**Non-Material Amendment**

**RE: Approval of the Reserved Matters; Appearance, Landscaping, Layout and Scale for the erection of 98 dwellings (including 34 affordable homes), provision of a junior football pitch, areas of public open space and off site highway improvements**

**AT: Land East Of King George's Field , Green Road, Haughley, IP14 3RA**

**REF: DC/19/05958**

Drawing No. EA159-SL-020C

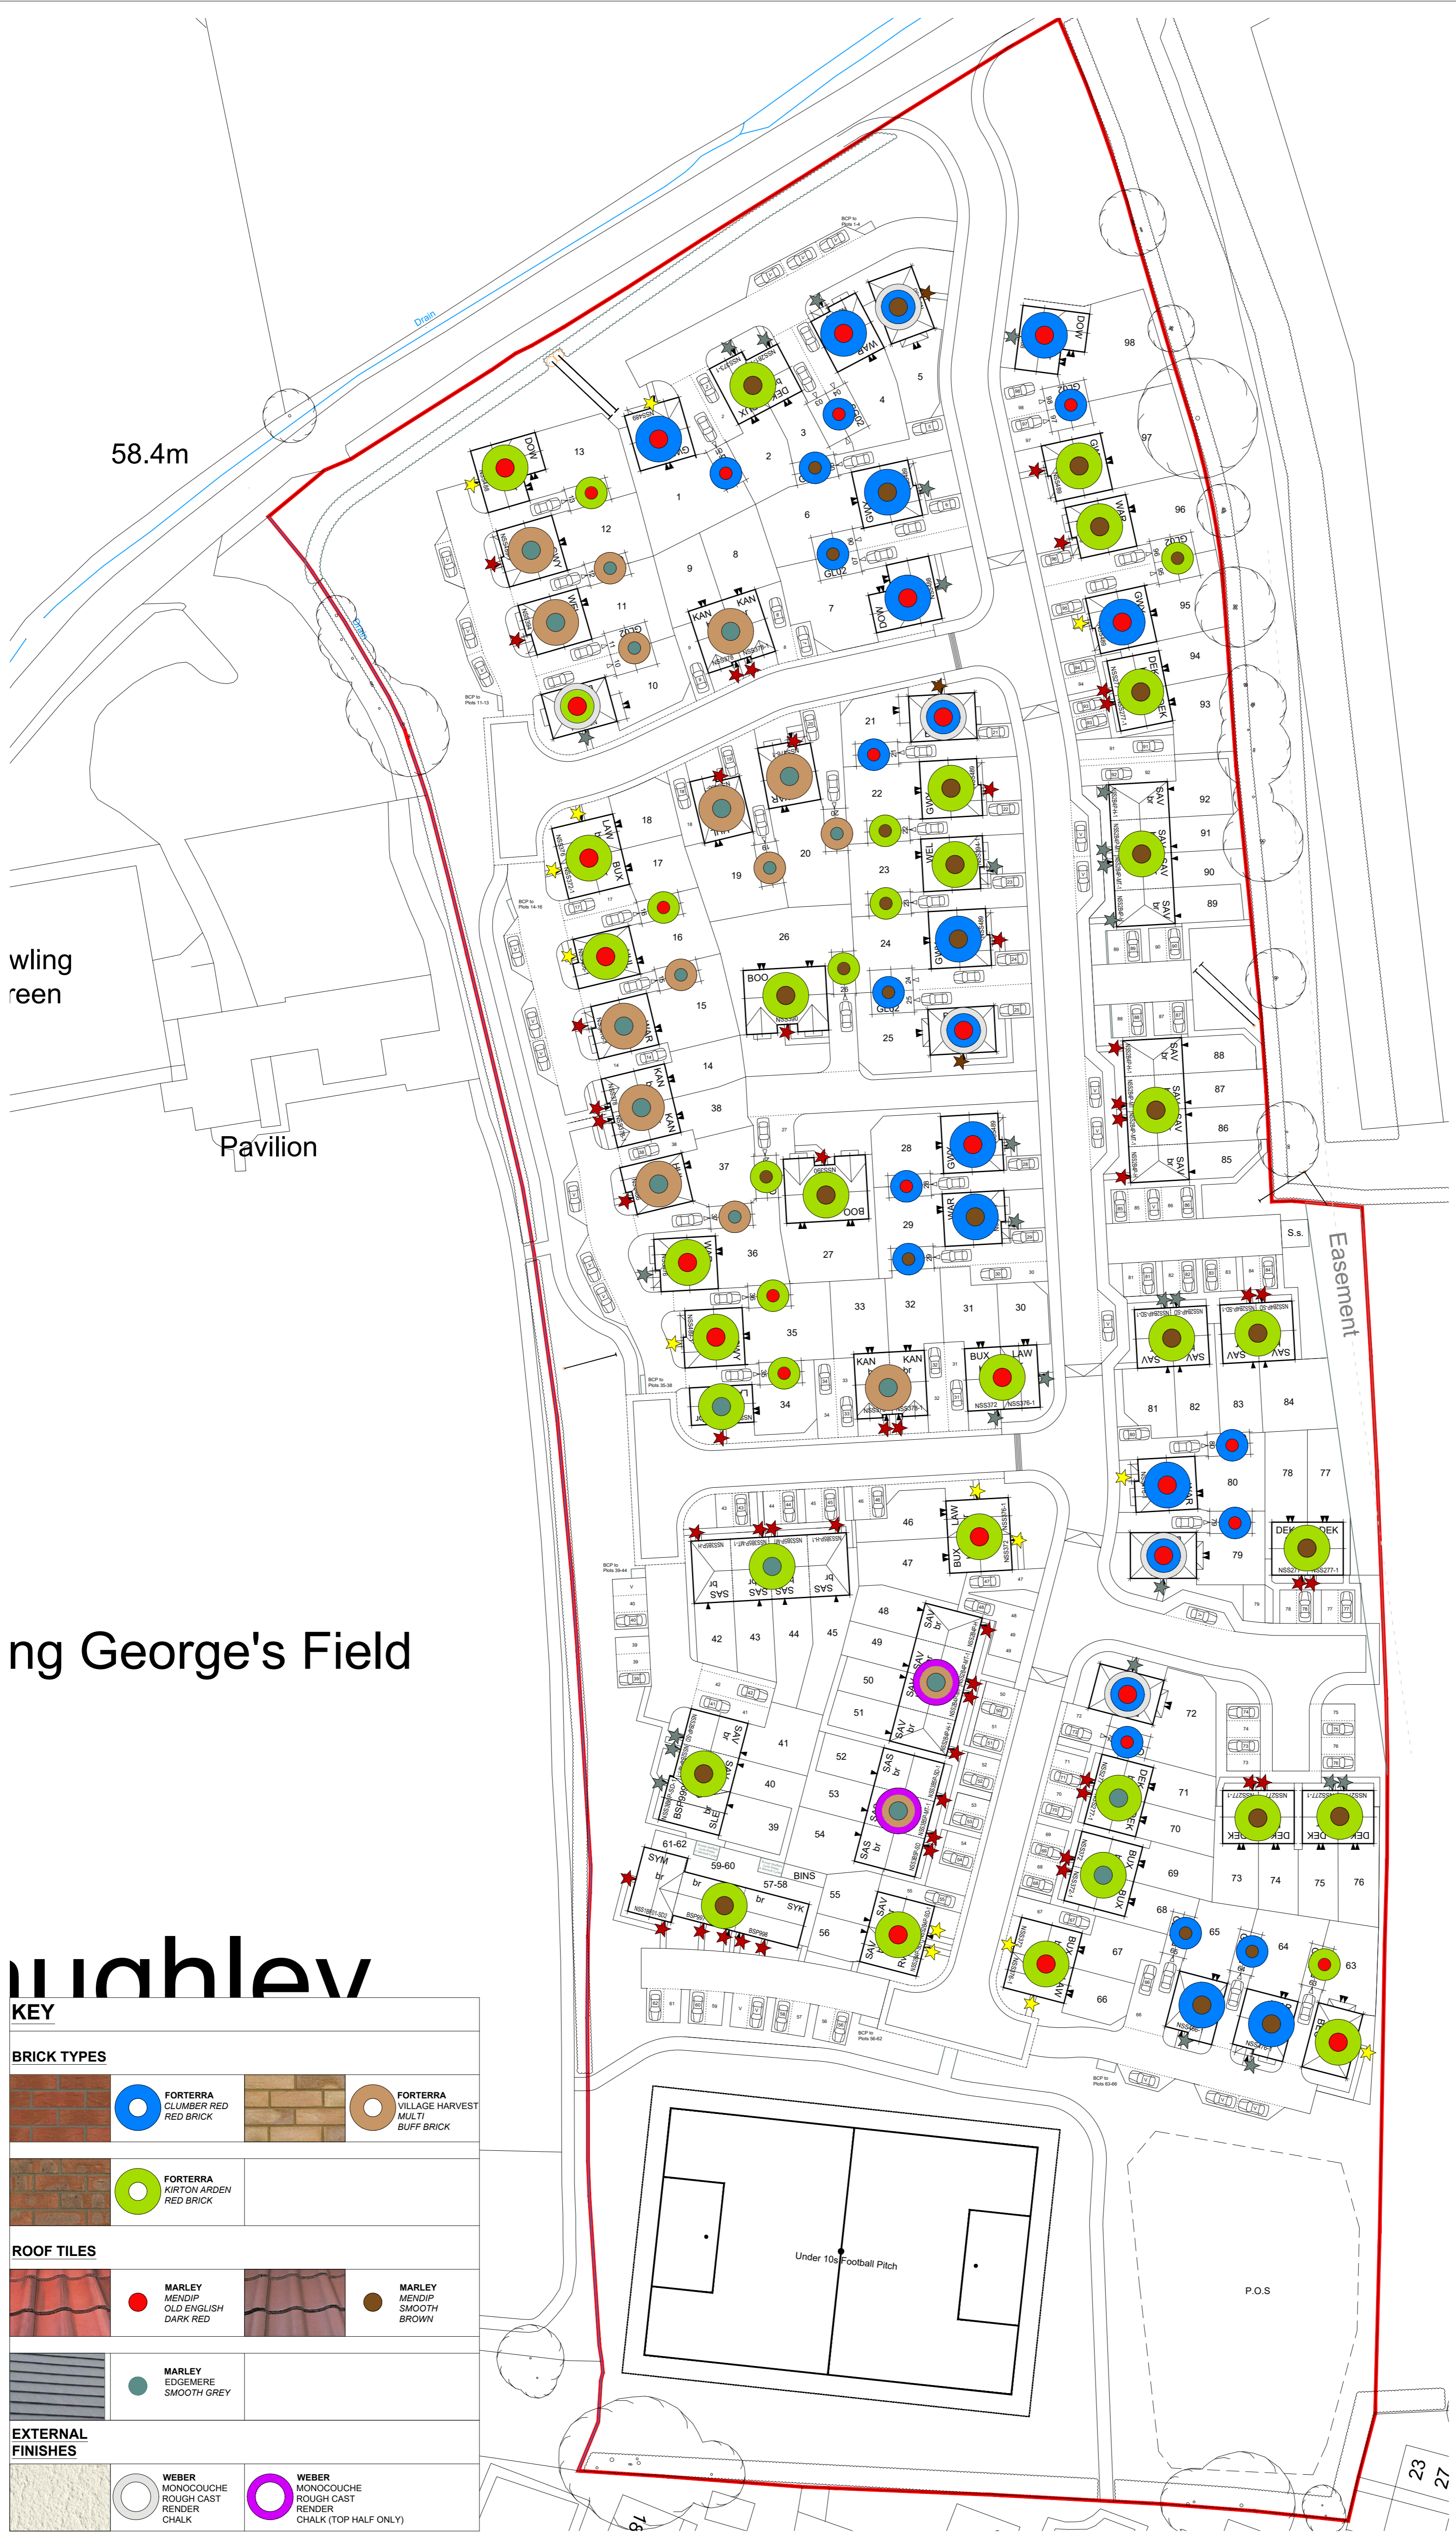
- Changing of the Forterra Village Harvest Multi brick to Forterra Kirton Arden Red brick to Plots 34, 42-45 & 68-71
- The addition of render to the top half of Plots 48-51 & 52-54.

The reason for this amendment is due to the shortage of the Forterra Village Harvest Multi brick.
